September 28, 2016

**RE: Bild Responses to Planning Staff Comments, 30 Merrill Street**

13 FENCE DETAIL NEAR CURB  
SCALE: 3/4" = 1'-0"

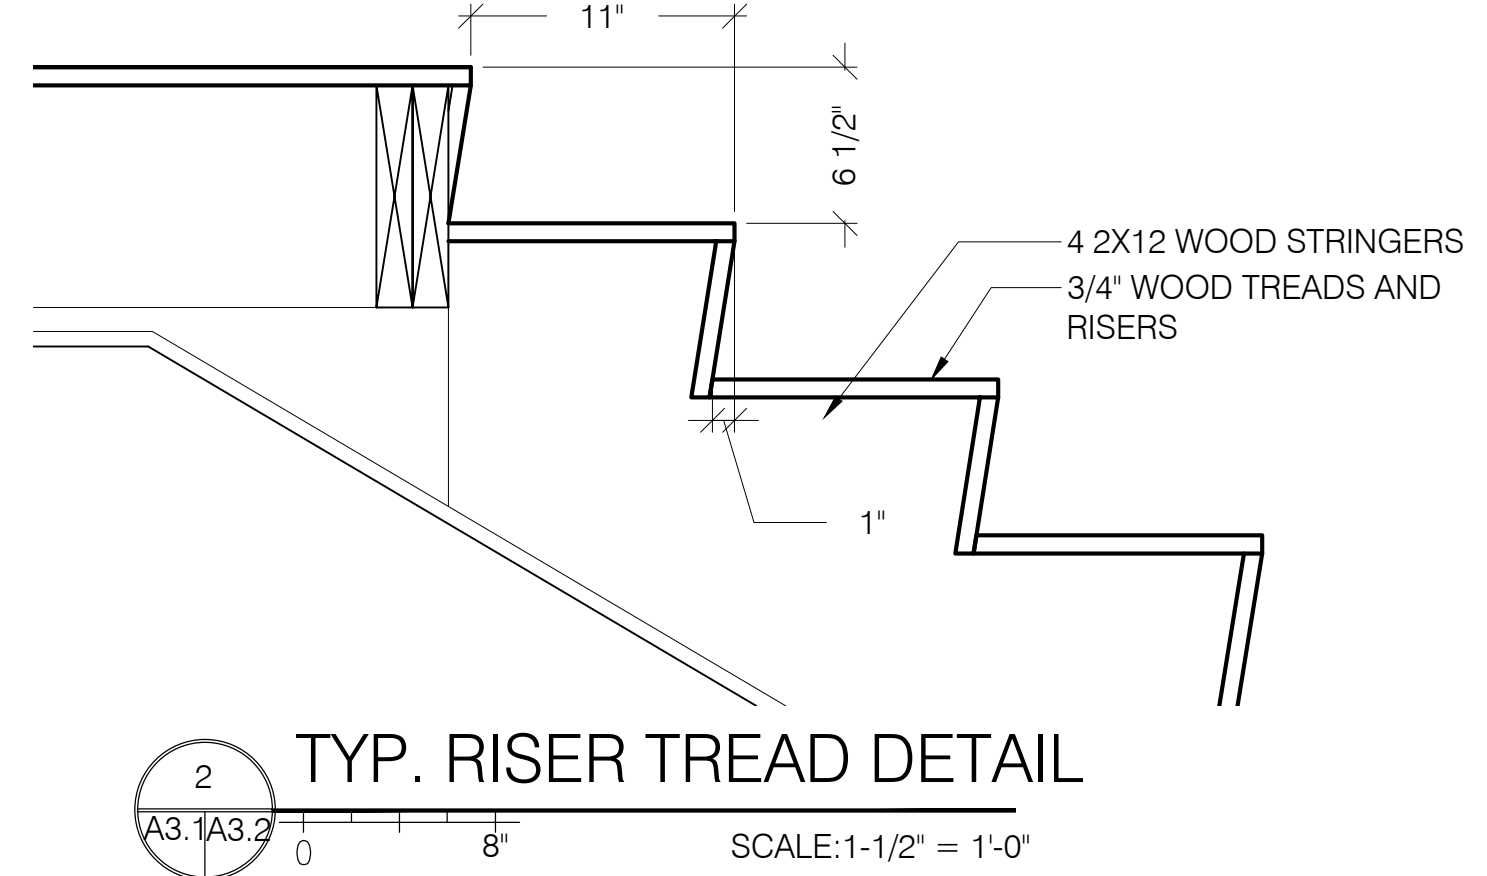
**A3.2 - DETAILS**

- Fence Detail provided
